Comments on the Applicant's Response to Relevant Representation from [REDACTED] of Foxley Road

Nurseries, Interested Party Reference Number: [REDACTED]

Title:
Figure 17-2: Agricultural Land Classification Mapping

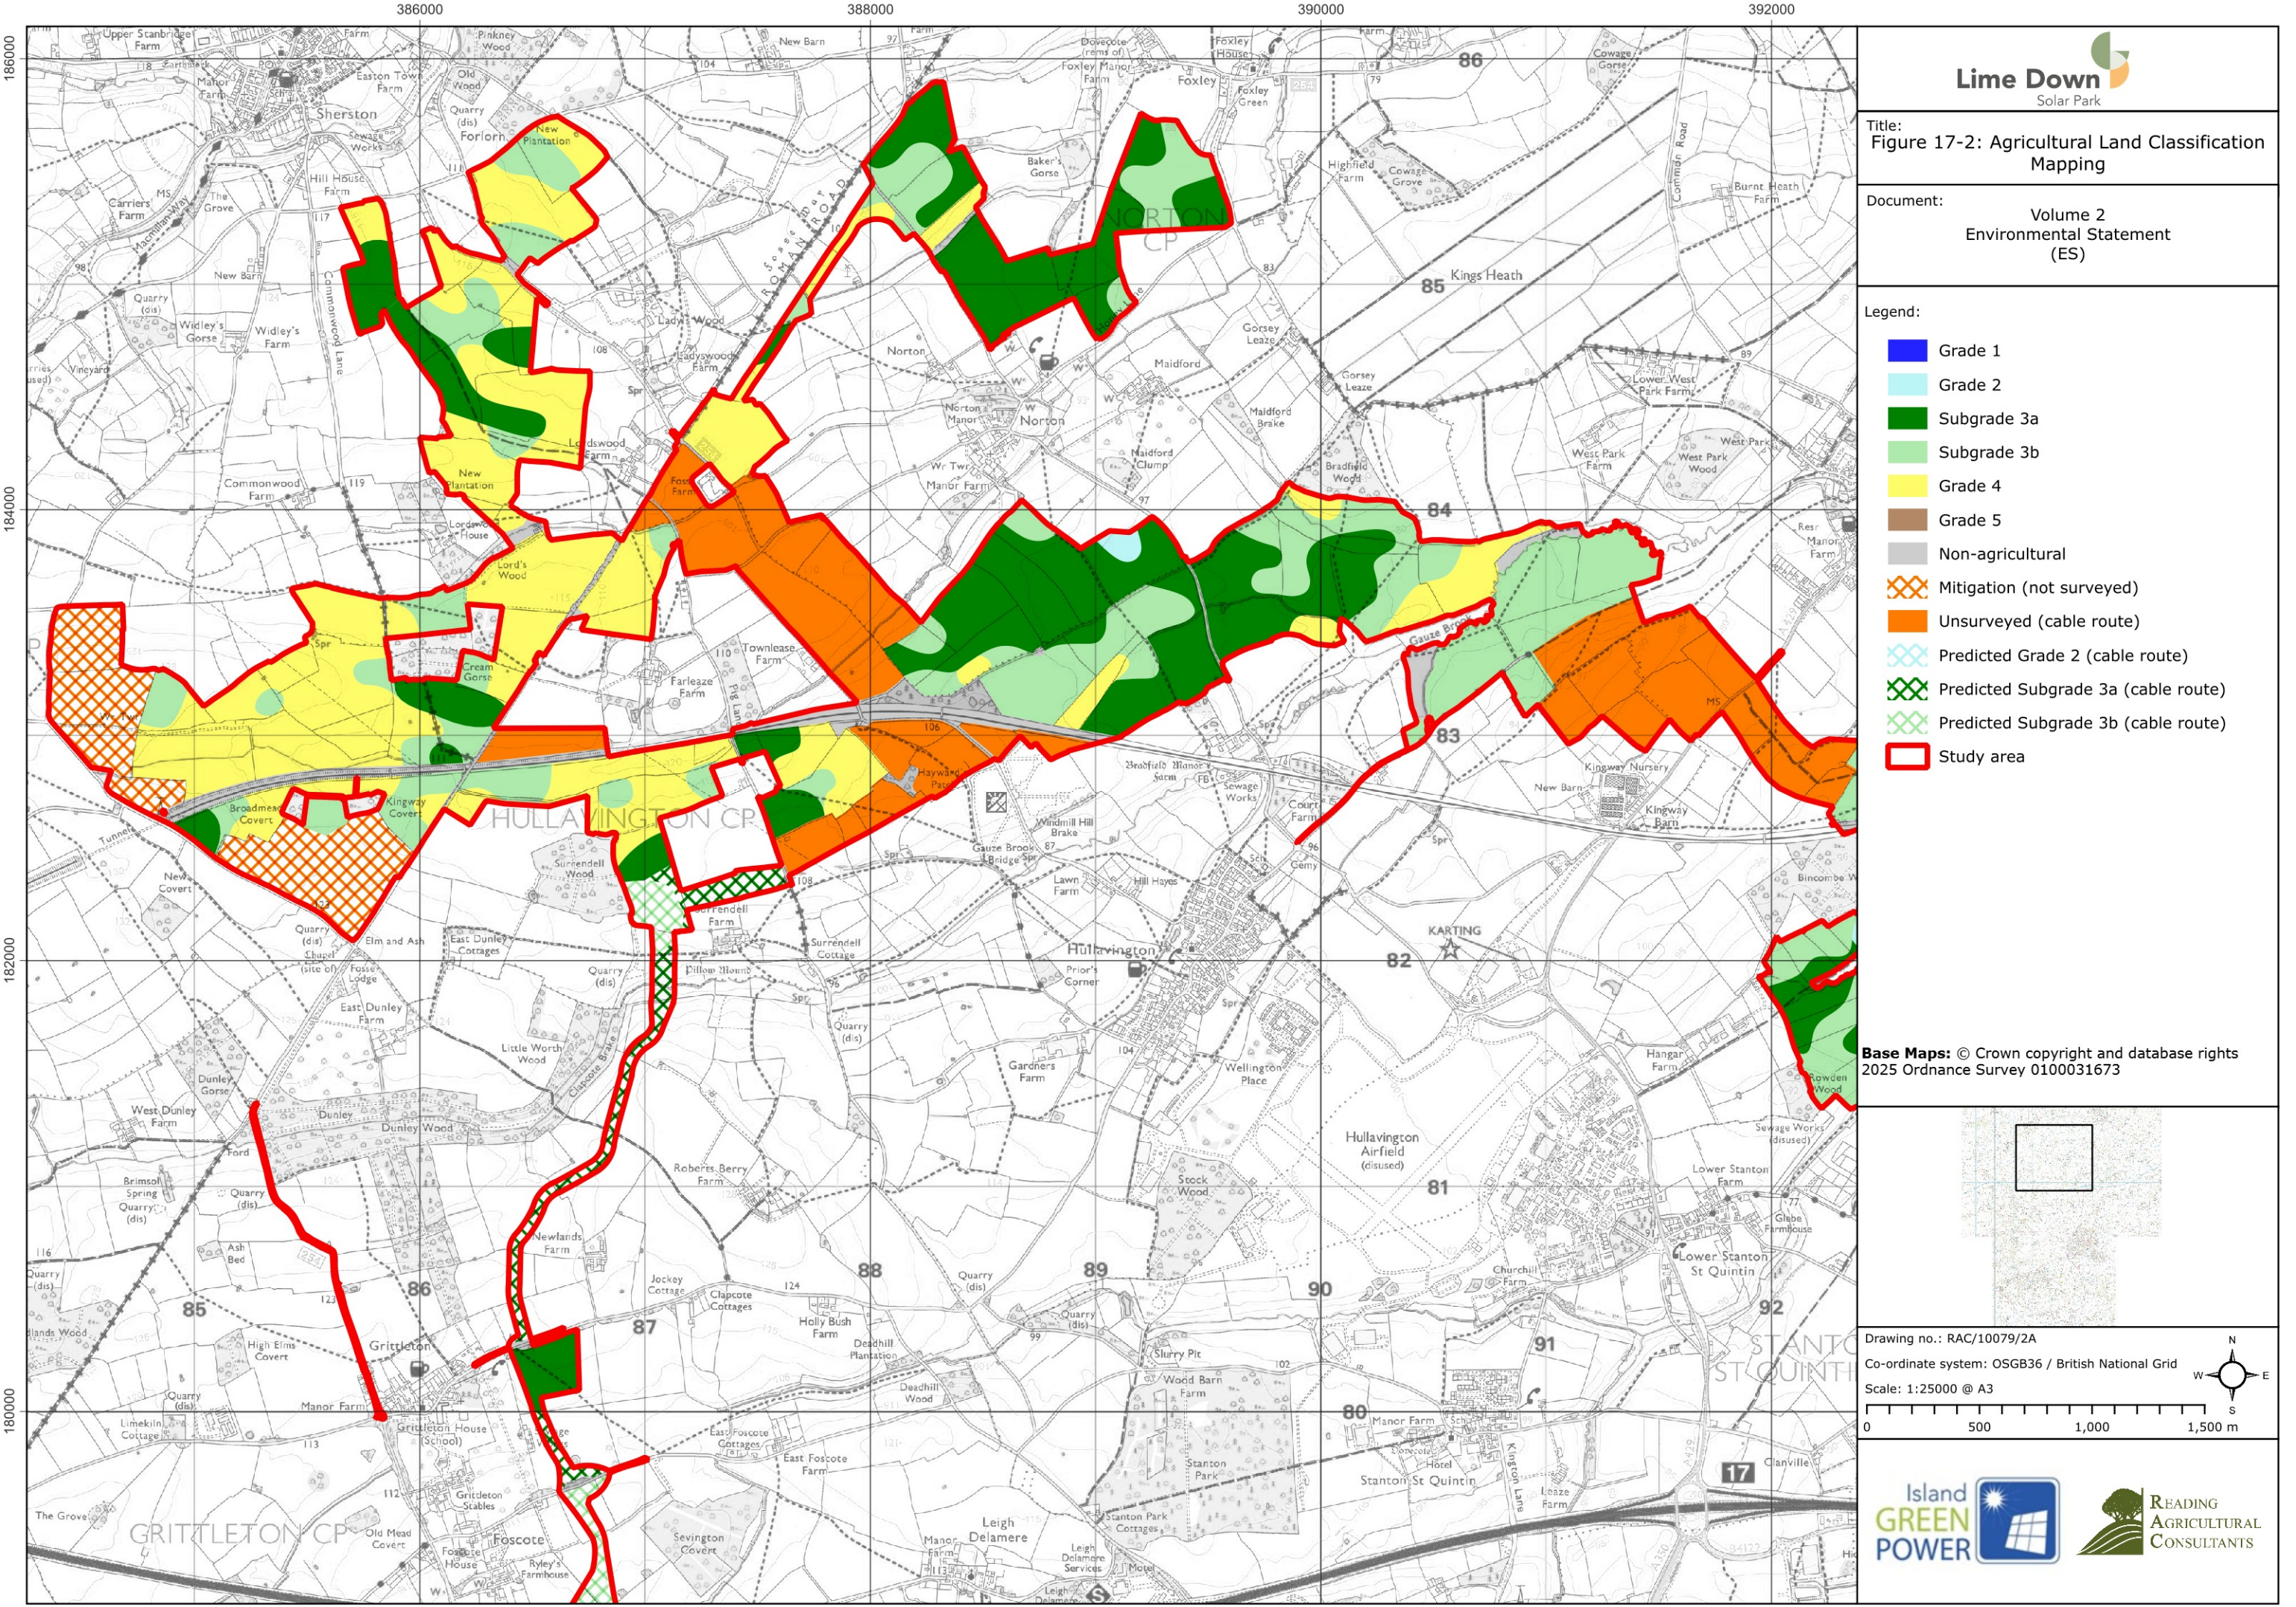
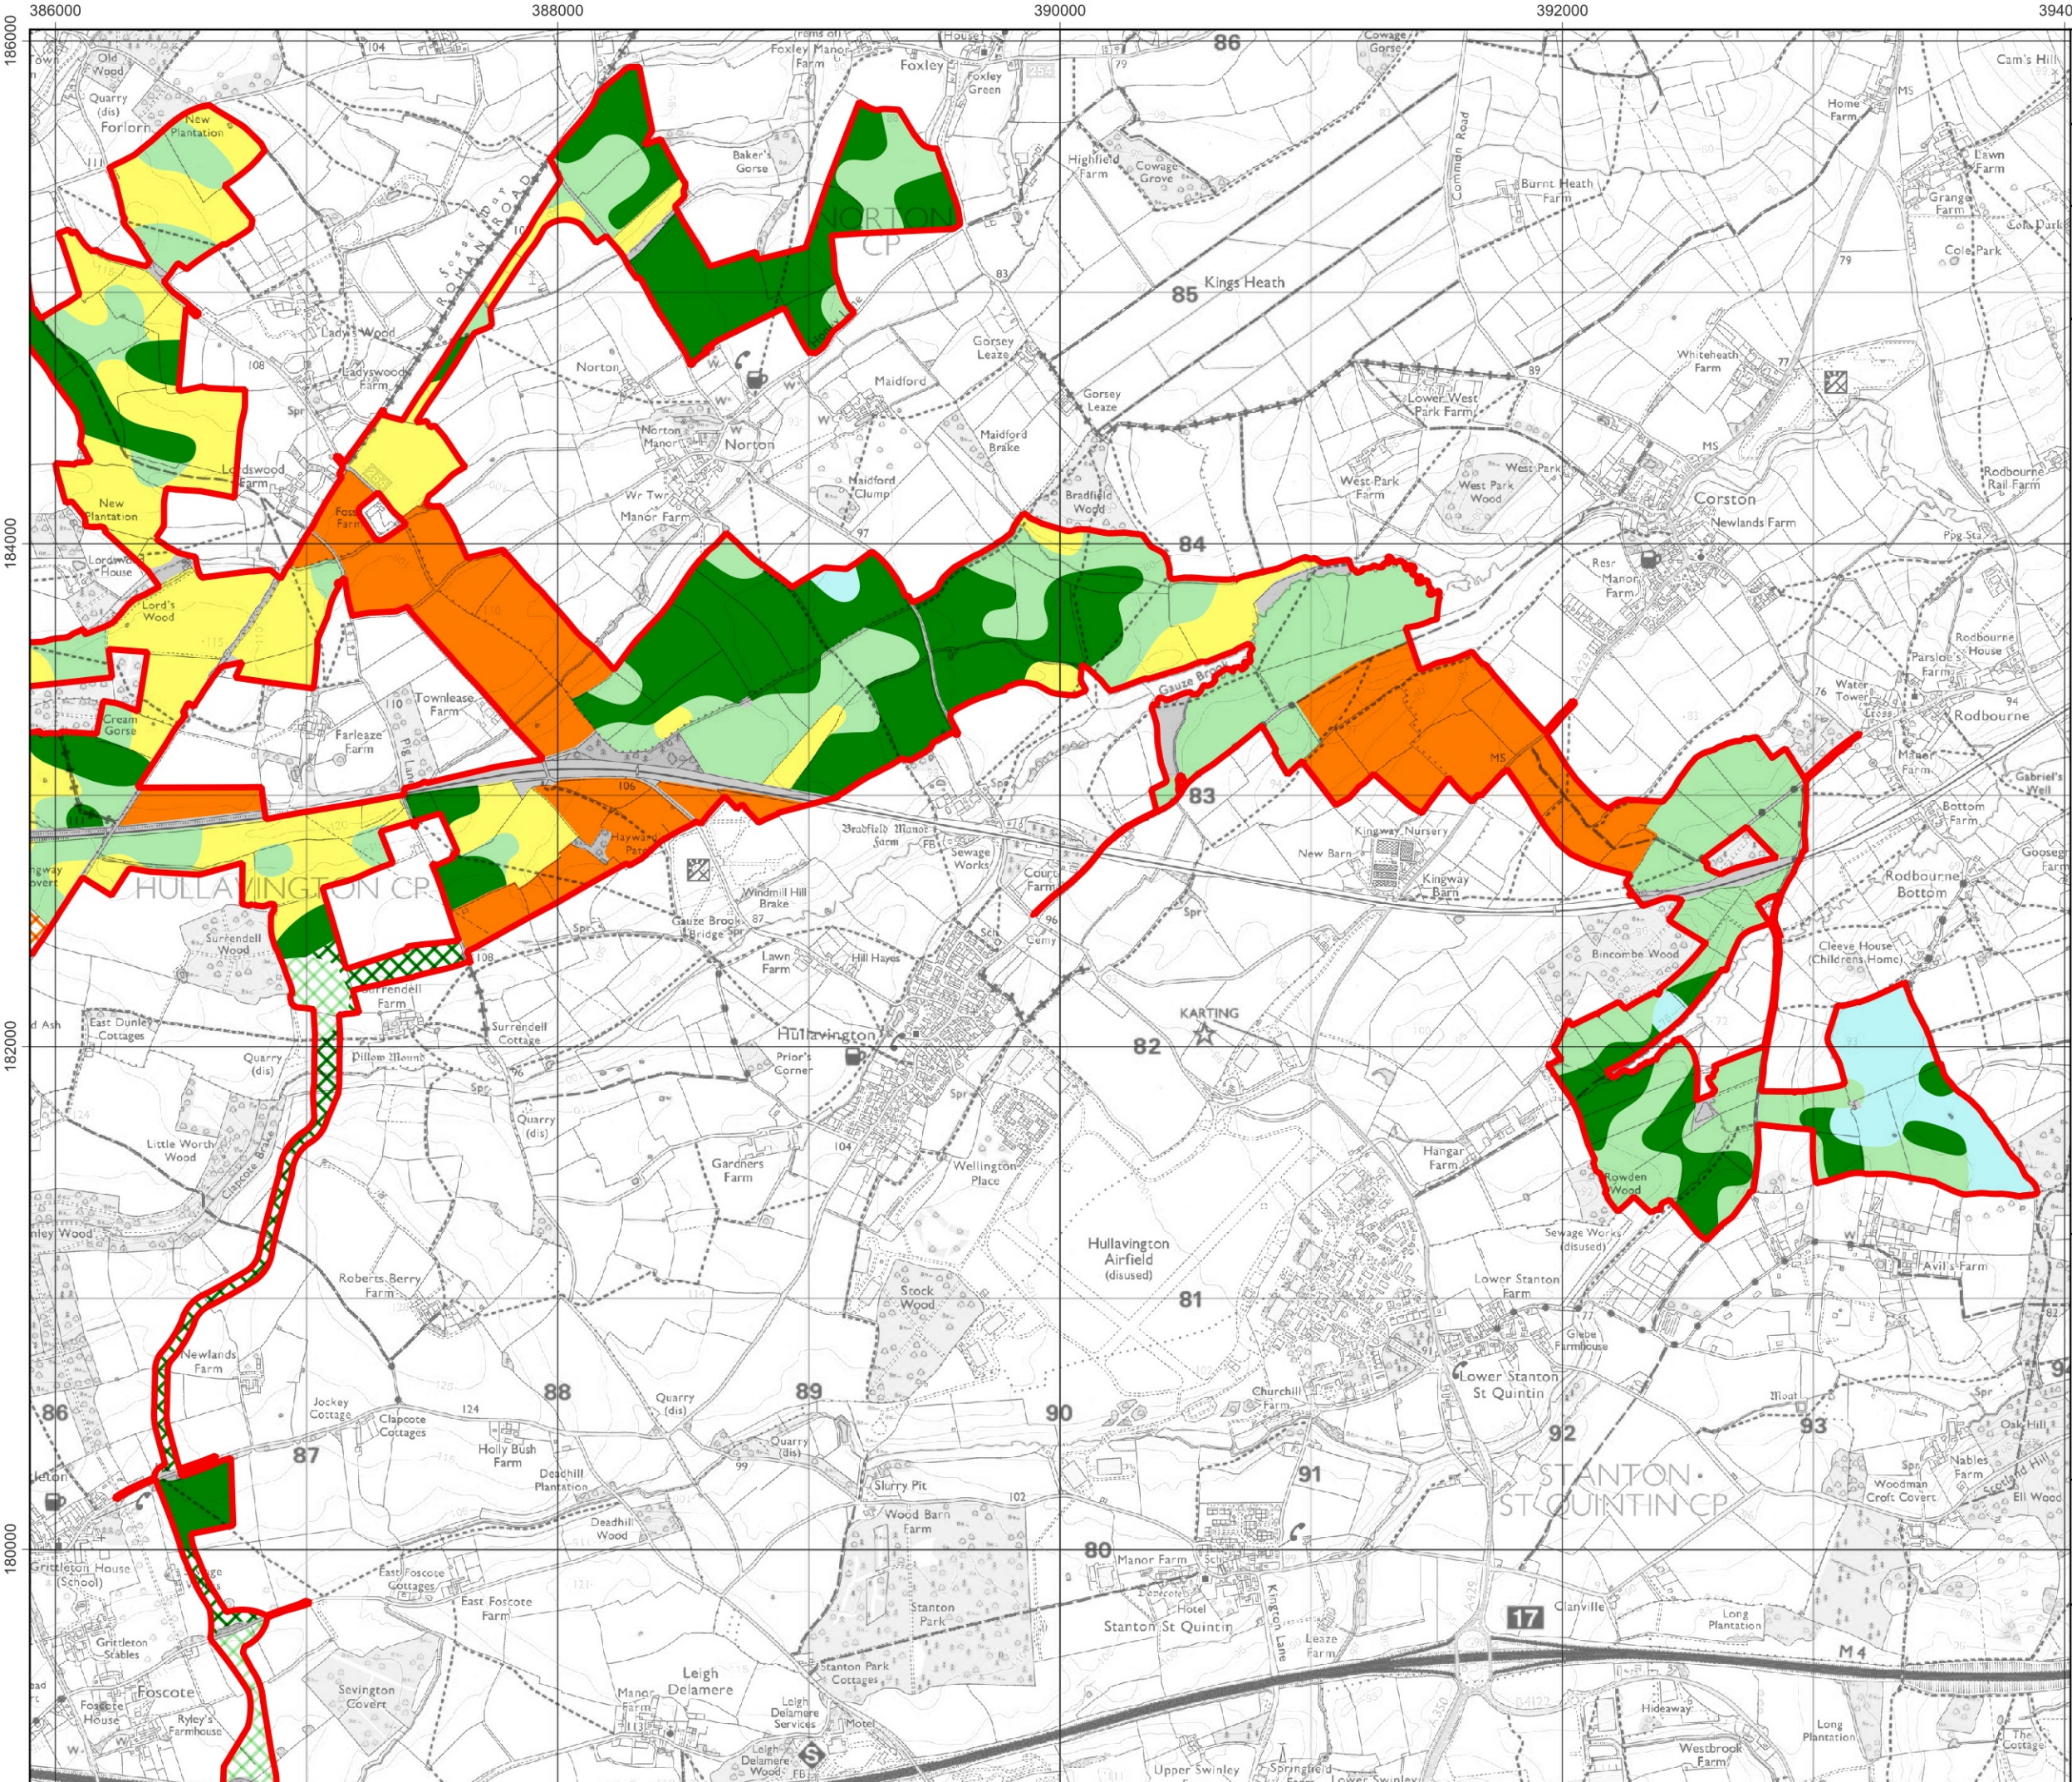
The Applicant's assessment of the proposed land identifies that the majority of agricultural land affected is not Best and Most Versatile (BMV) land, comprising predominantly Subgrade 3b and Grade 4 land, which is not considered high quality agricultural land in planning terms, however local farmers including tenant farmers have grown food and earned a living from that land over many centuries. At the end of the lifetime of the scheme, disposal of the panels, concrete, etc will have a huge environmental impact and will involve another extended period of HGV movements. Severe compaction of the ground will be extremely difficult to remedy. It is hard to believe that the entire area will be reinstated as farmland.
